JS STREAM SCF  
UT TO UT AT BELMONT  
ABBEY COLLEGE

MATCHLINE -Y7A- STA. 30+00, SEE SHEET 26

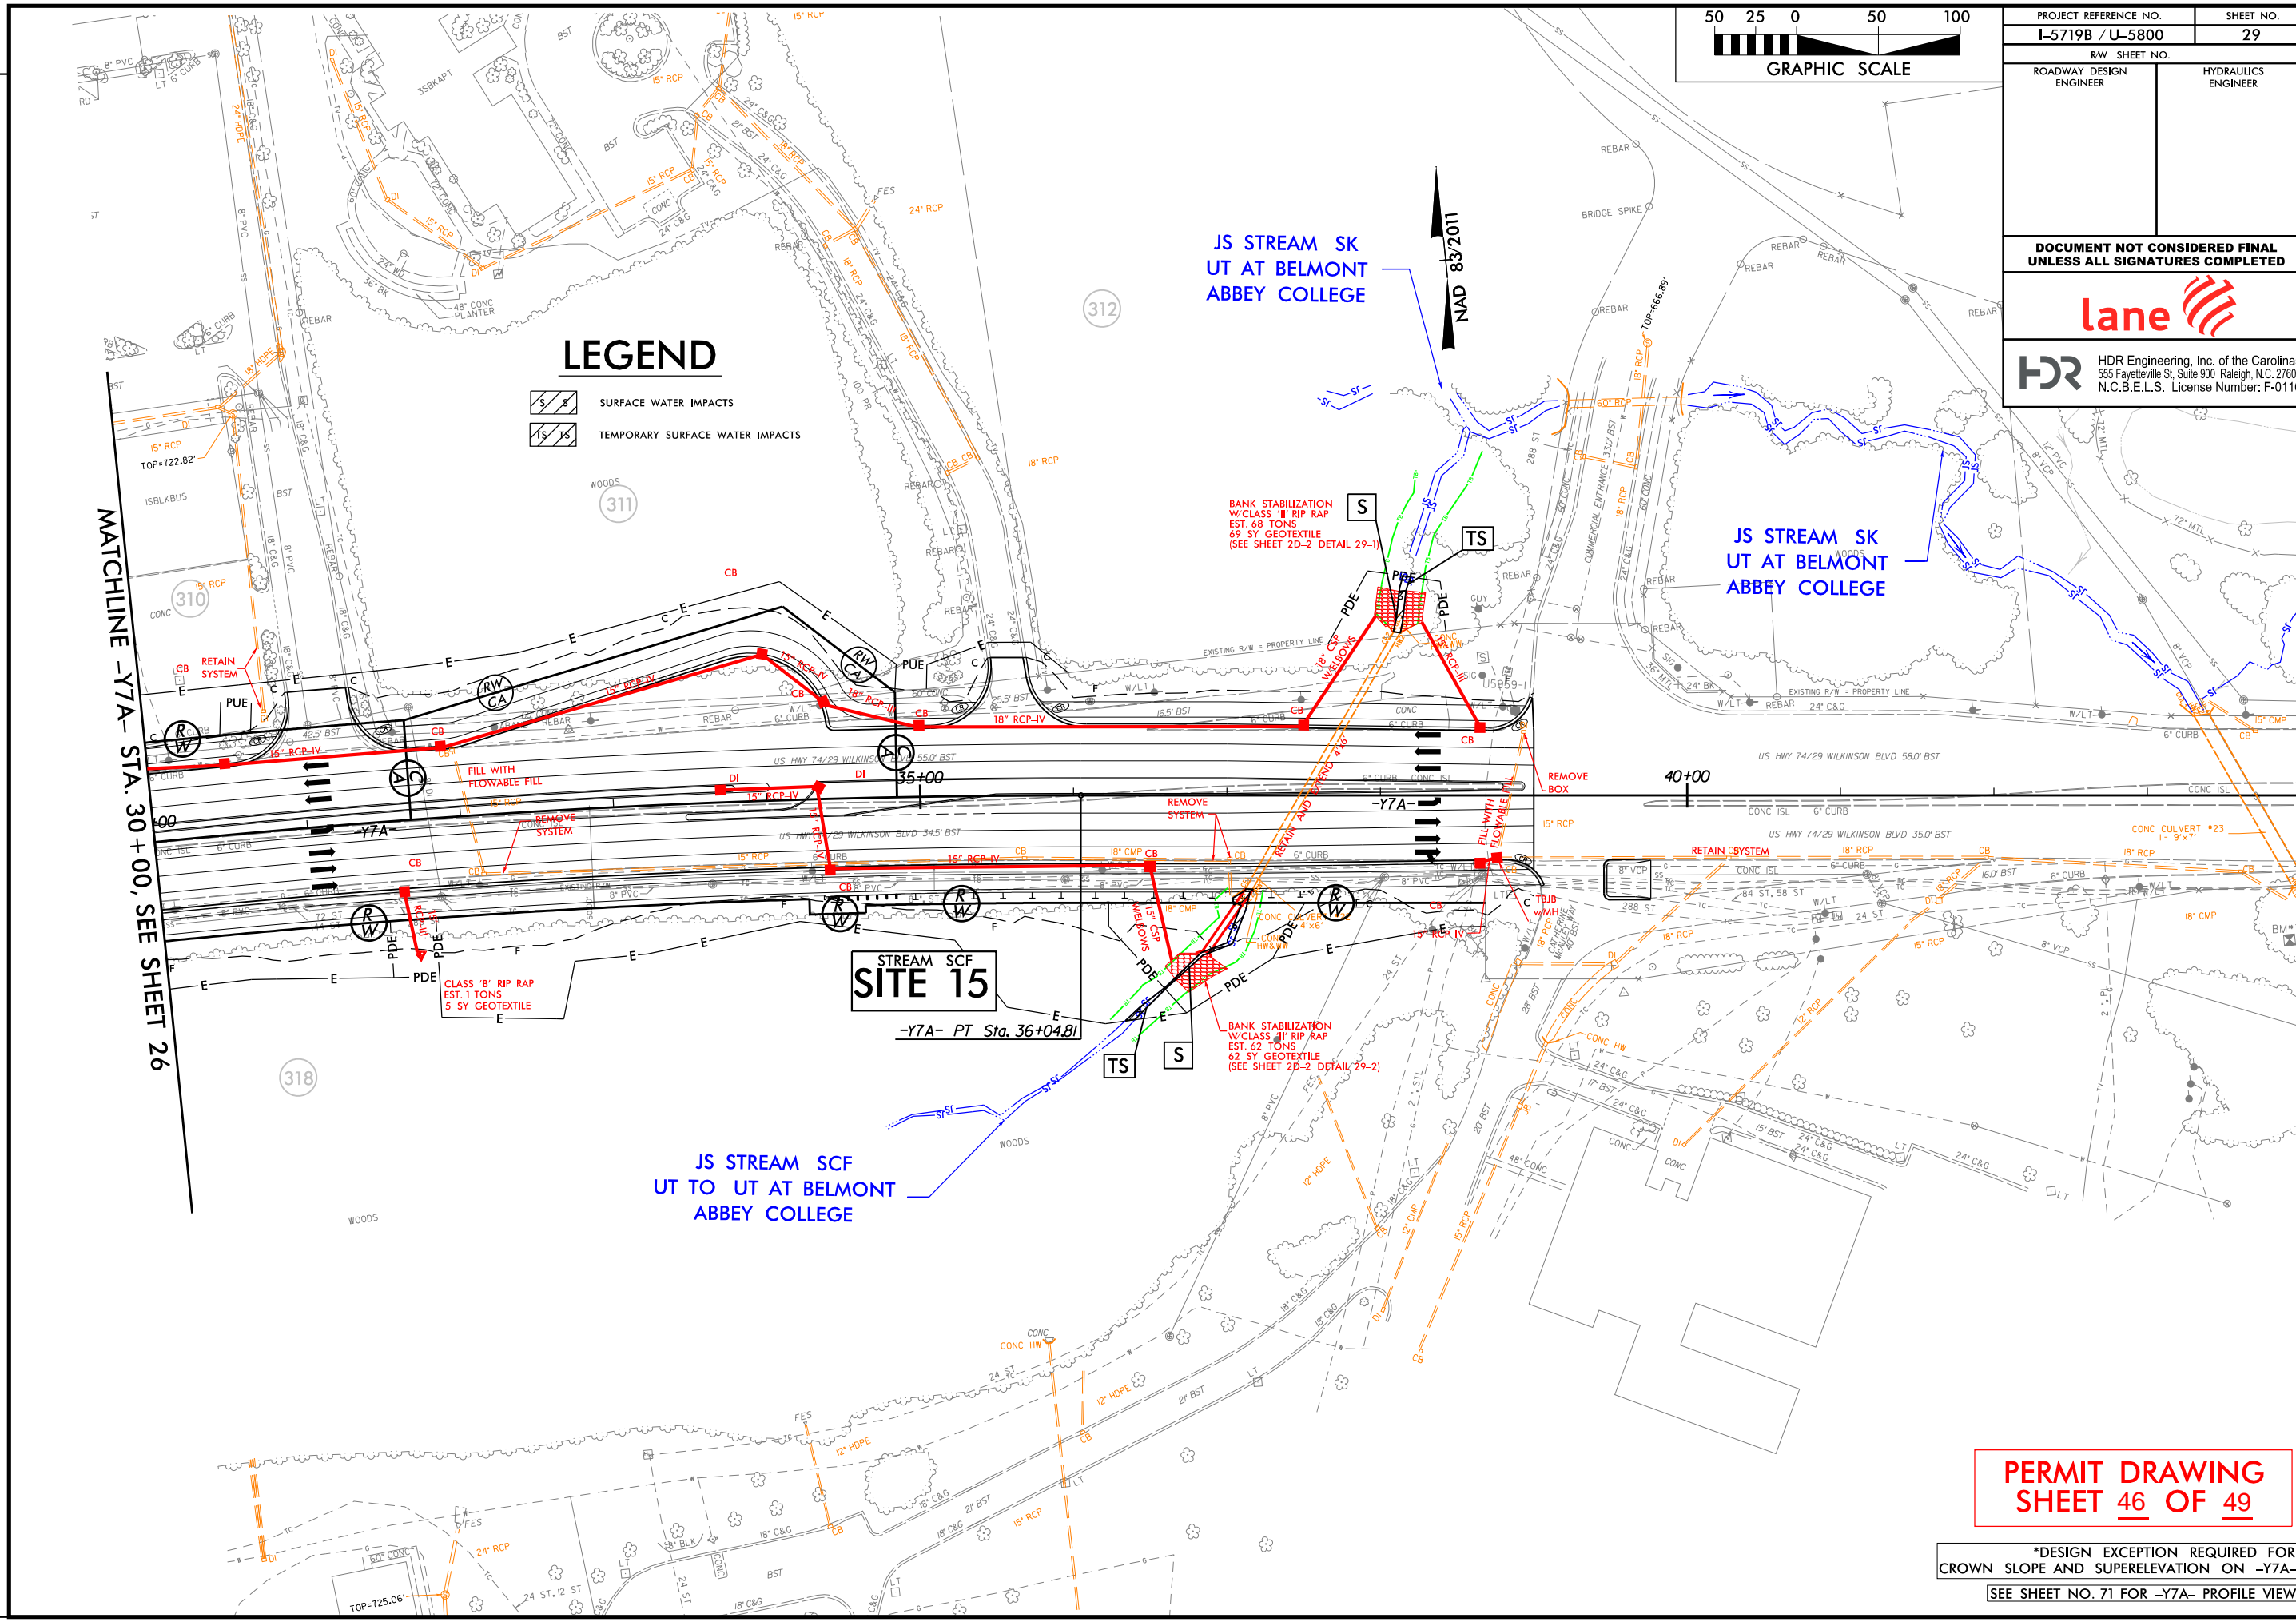
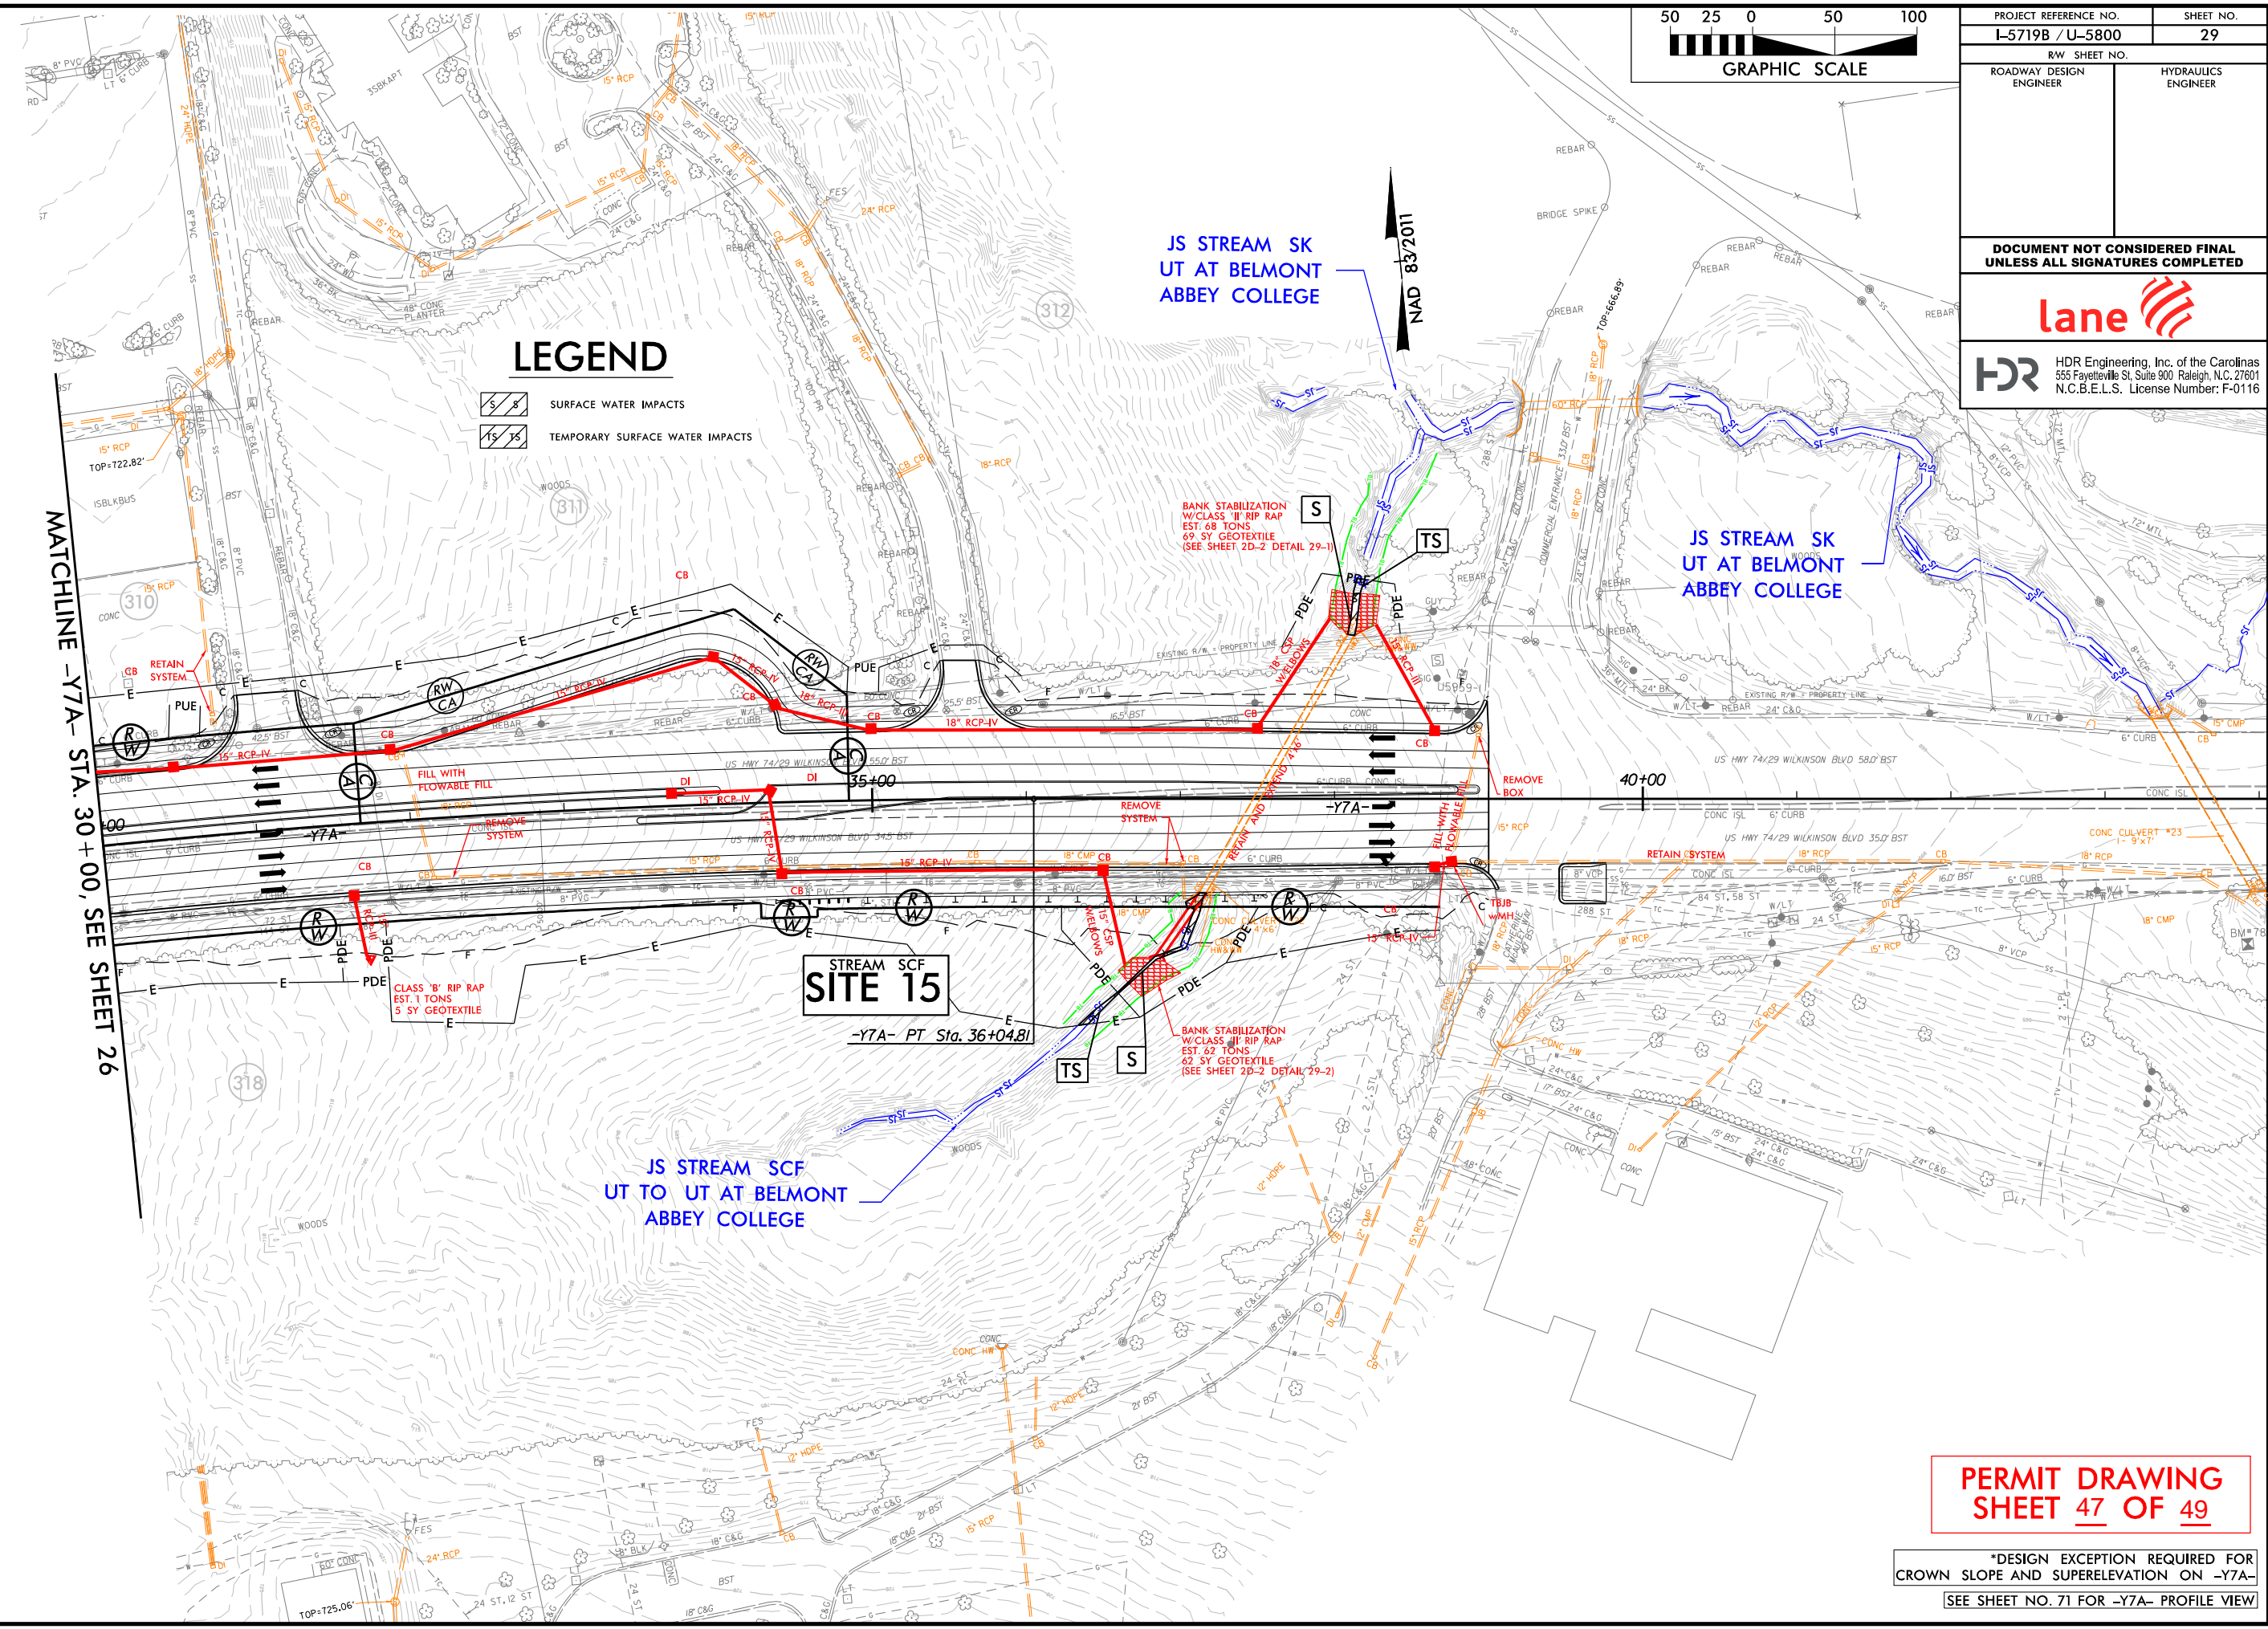
This stream should be labeled as "SK" to be consistent with the other reach of this stream depicted on Sheet 15 (in the I-5719B portion of the project).

Also, the correct 'name' for this stream is: "UT at Belmont Abbey College".
